**ADC Planning Consultation
Conservation/Design Officer Response**

Application Number	Y/89/17/L
Address	Dyers Croft, Main Road, Yapton
Description	Listed Building Consent to demolish existing open garage/store and replace with new garage
Case Officer	Mr R Temple
Date	24 th January 2018

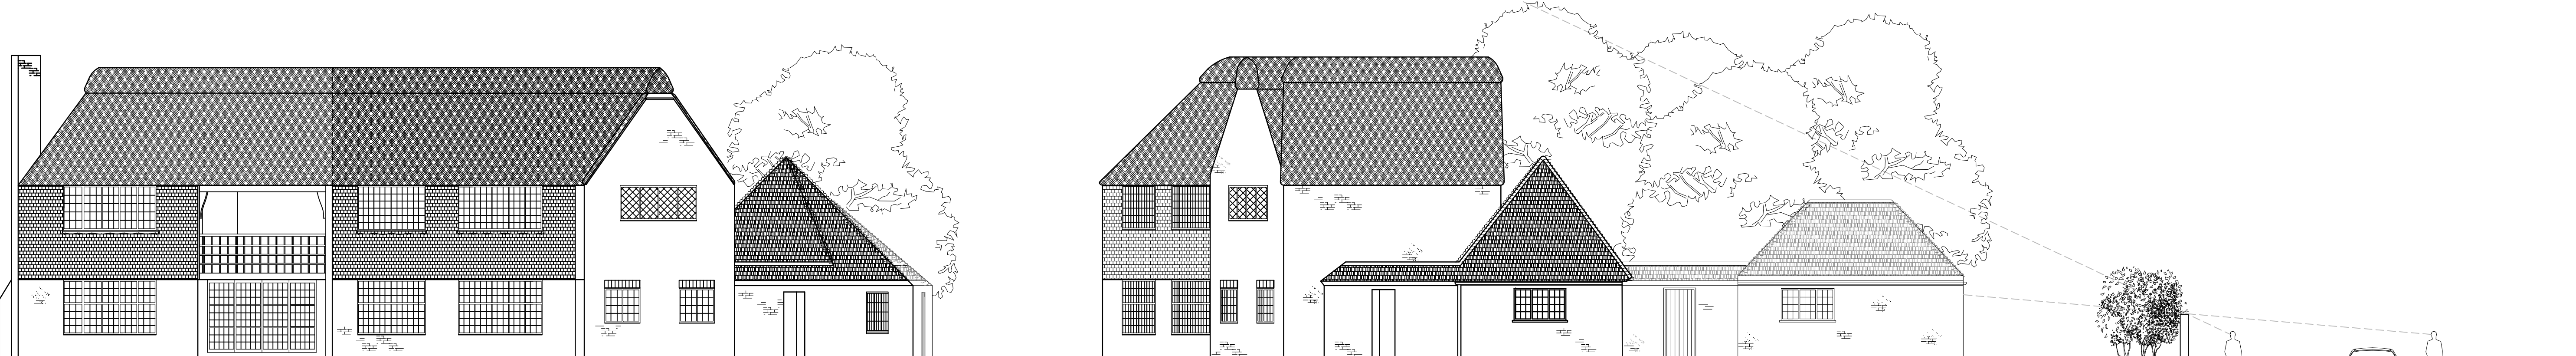
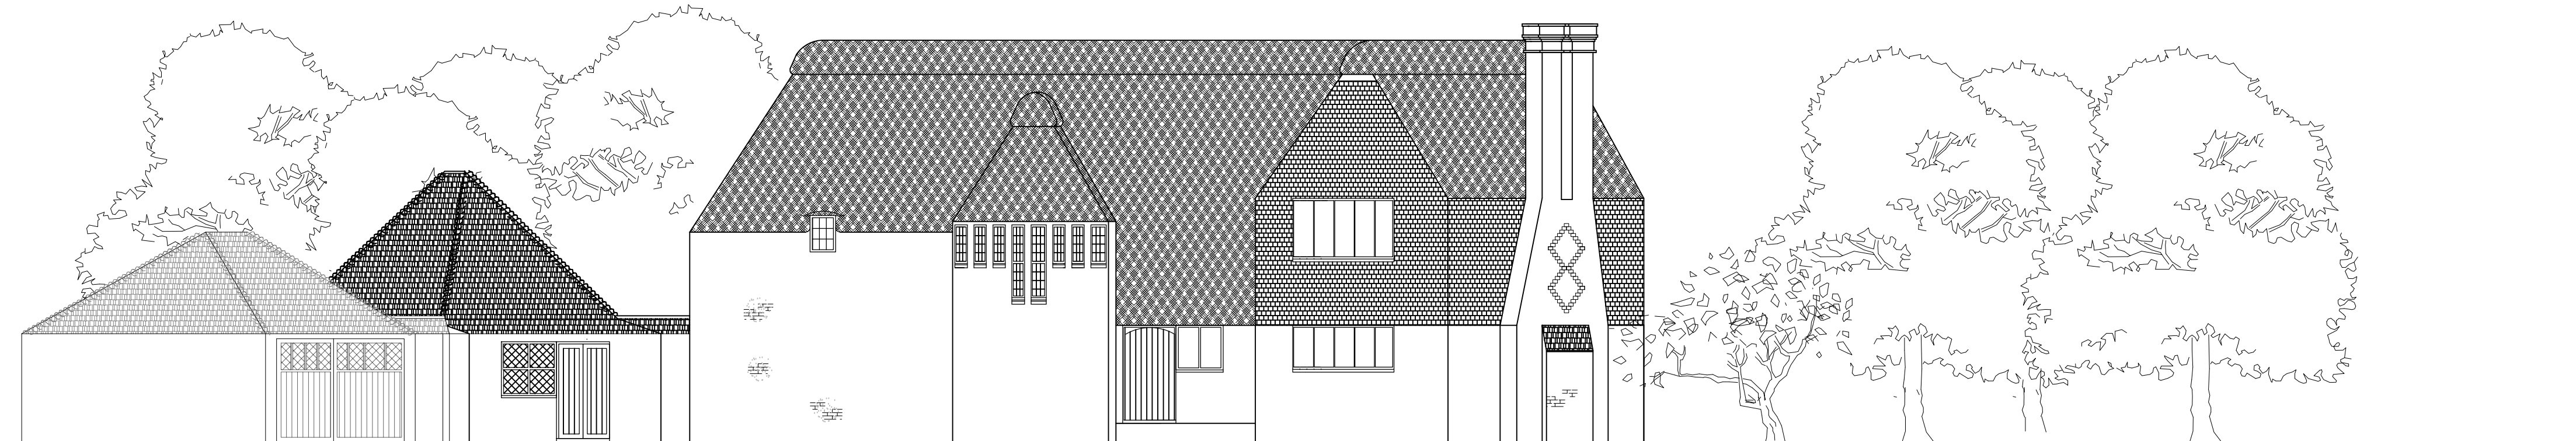
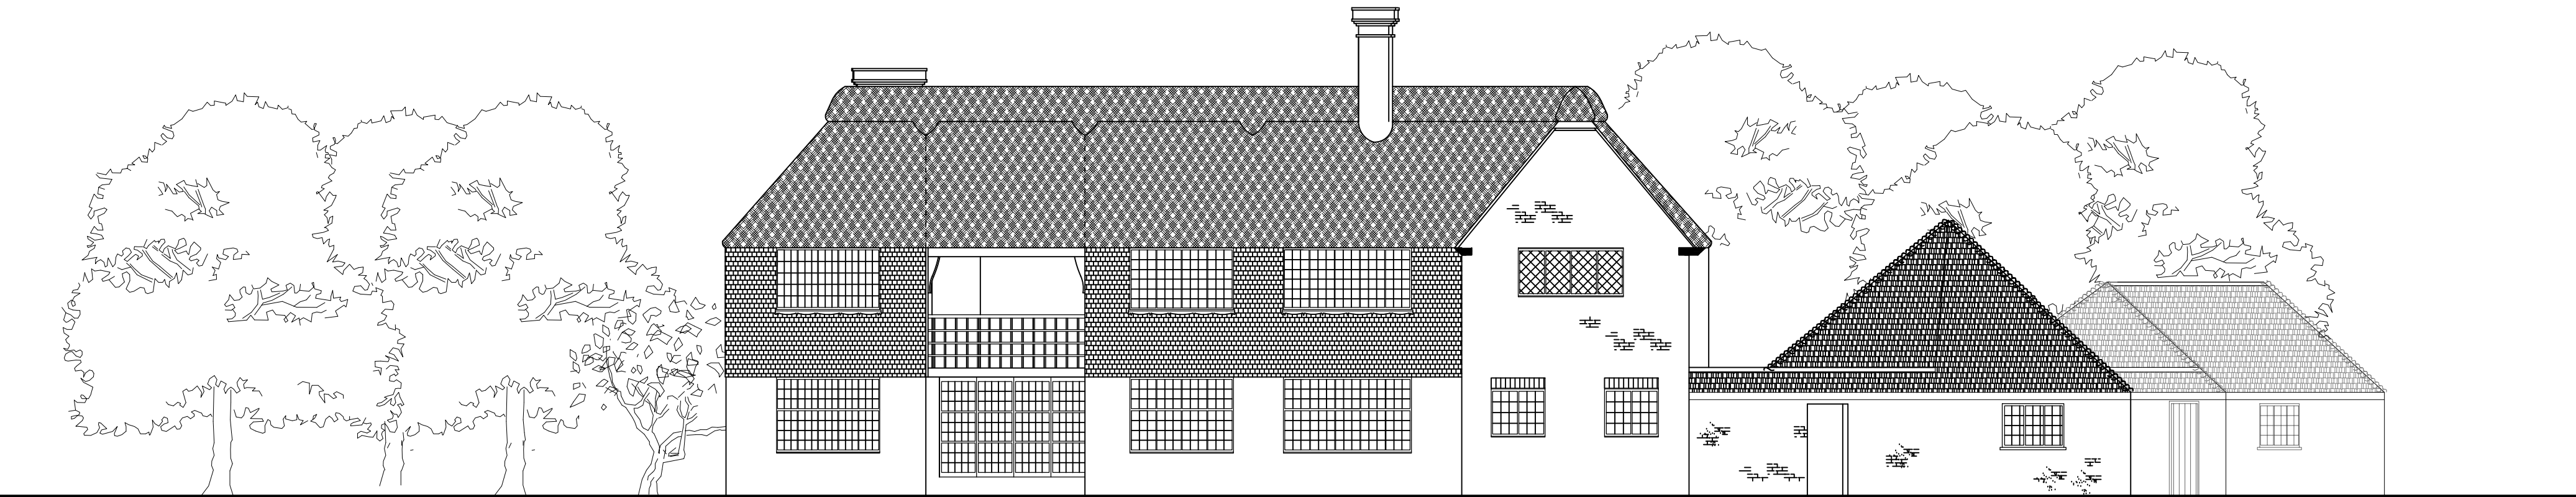
The proposal is to remove an existing open carport/store and replace with a double garage under a pitched tiled roof.

The proposal is considered overly dominating and would harm the setting of the listed building, to which it would be attached. It is considered that the proximity and massing of the proposed is considered detrimental to the listed building, and the setting of a listed building. Proposed materials beyond 'to match' are not specified, as it is unclear as to whether this is the house/existing adjacent store is unclear, so it is not possible to comment on this aspect of the application.

- It is considered that the proposal fails to conserve or enhance the setting of the listed building, or its planned garden space.
- It is considered that the proposal does not adequately respond to local material, form or scale and adversely affects the character appearance and views in and out of the Conservation Area.
